From: [Wolfenbarger, Jeanne](#)
To: ["jeffwooten.pe@gmail.com"](mailto:jeffwooten.pe@gmail.com)
Subject: K09-D038 Applebee's (Traffic Circulation Layout and Grading and Drainage Plan) Review
Date: Monday, April 06, 2015 4:38:09 PM
Importance: High

Regarding the Traffic Circulation Layout, you have addressed all comments with some minor exceptions:

Traffic Circulation Layout

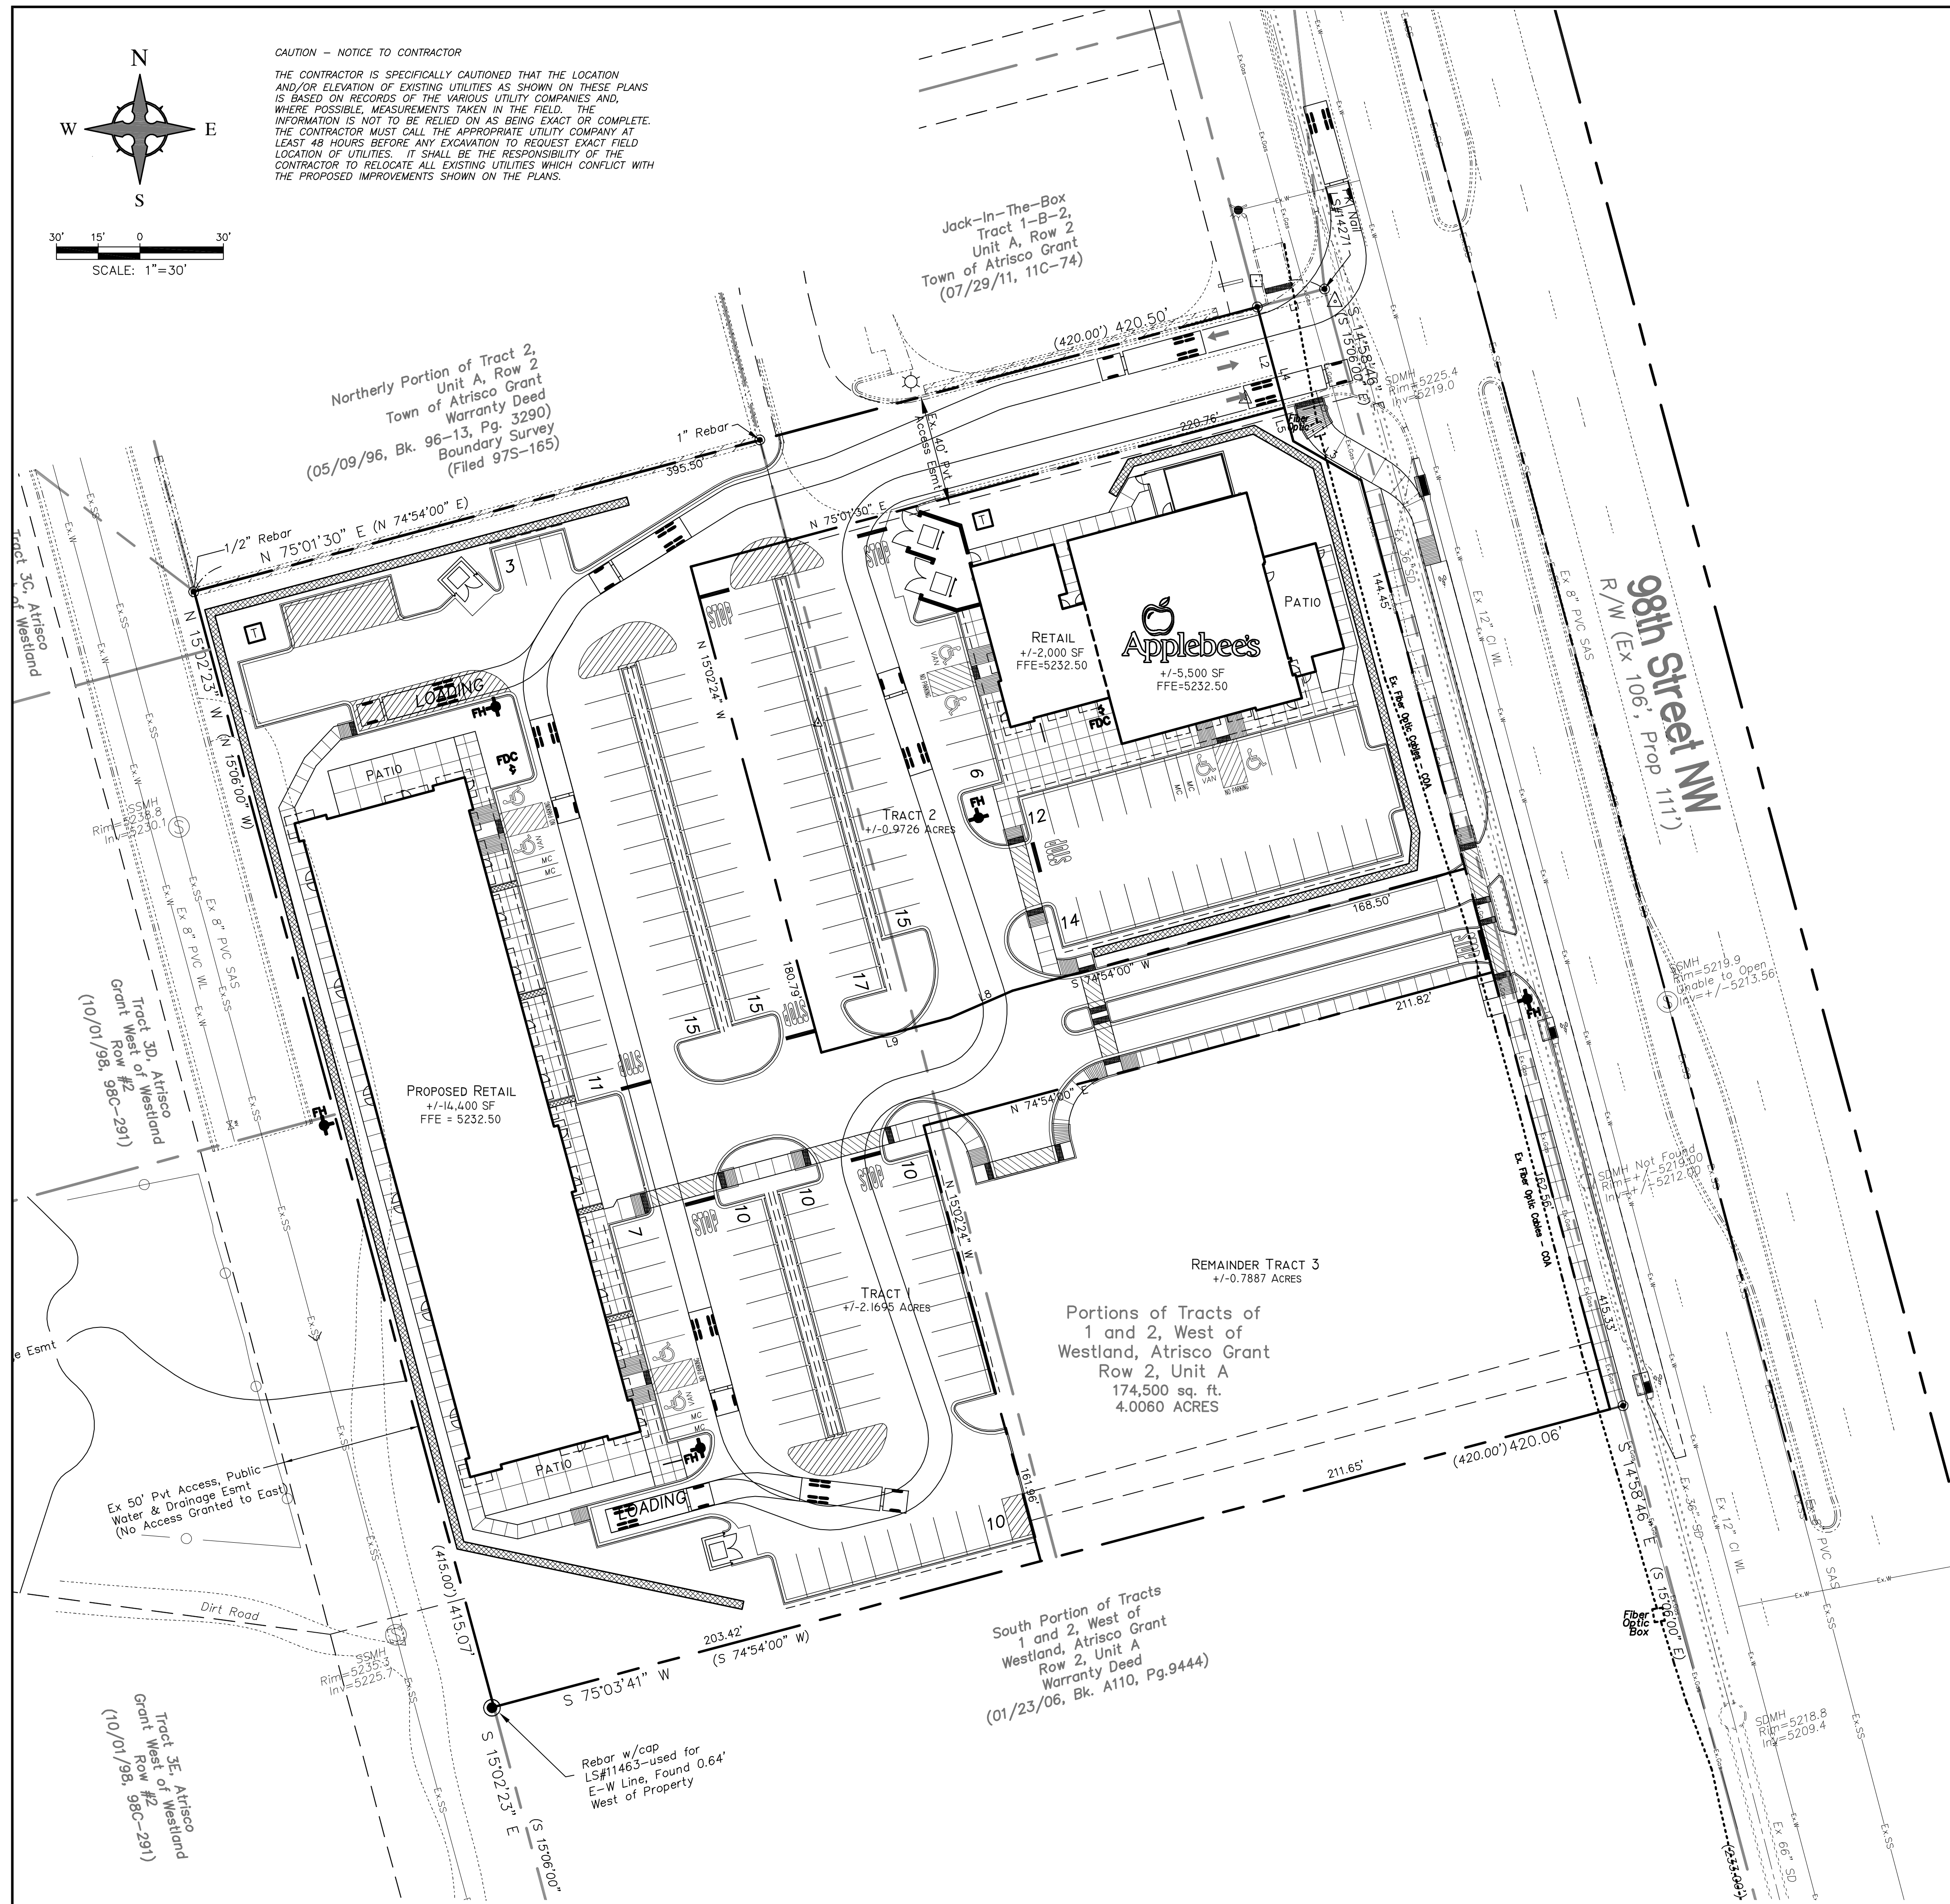
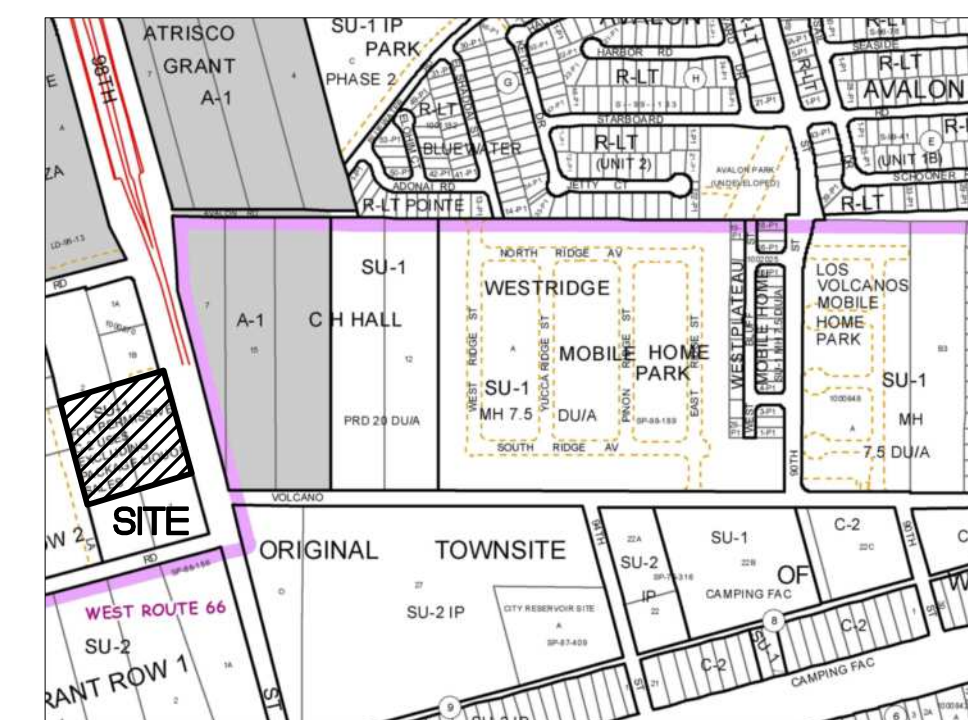
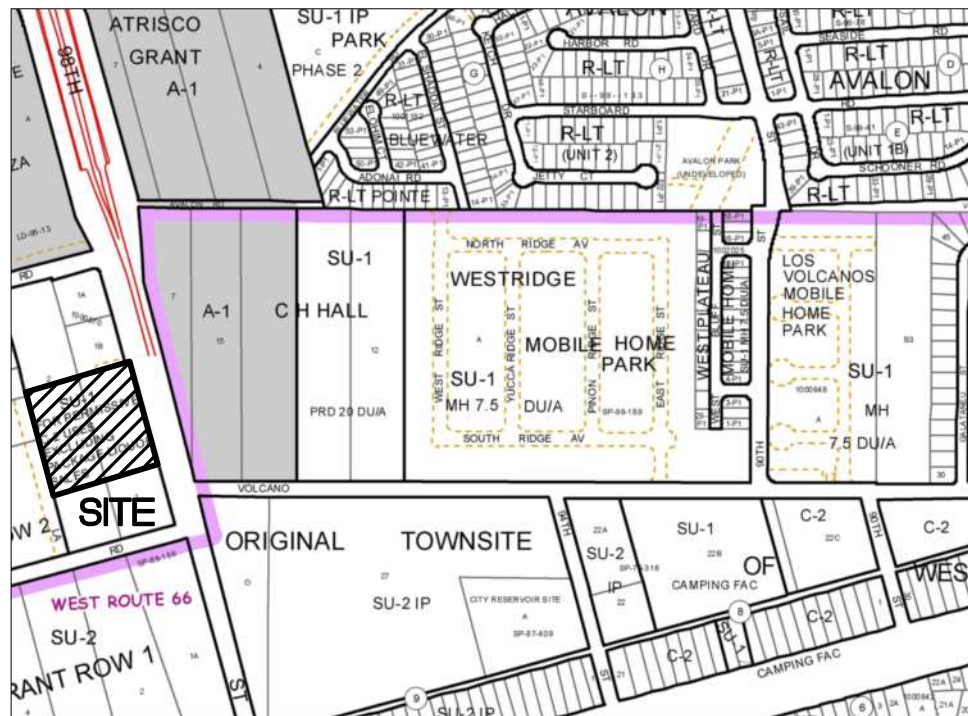
1. We still need to show a truck delivery route for approval. This has been standard for our Traffic Circulation Layout reviews. Show how a truck can navigate through the parking lot with the necessary turning movements. You may show this informally on a separate sheet which is what a lot of people often do to avoid cluttering the site plan.
2. Call out Keyed Note 30 for both driving entrances for the clear site triangle. (On one of them, you show Keyed Note 35.)
3. Label 24' aisle on the north end just west of where you show the 40-foot easement to make it clear that 2-way traffic can navigate through the north aisle of the site.
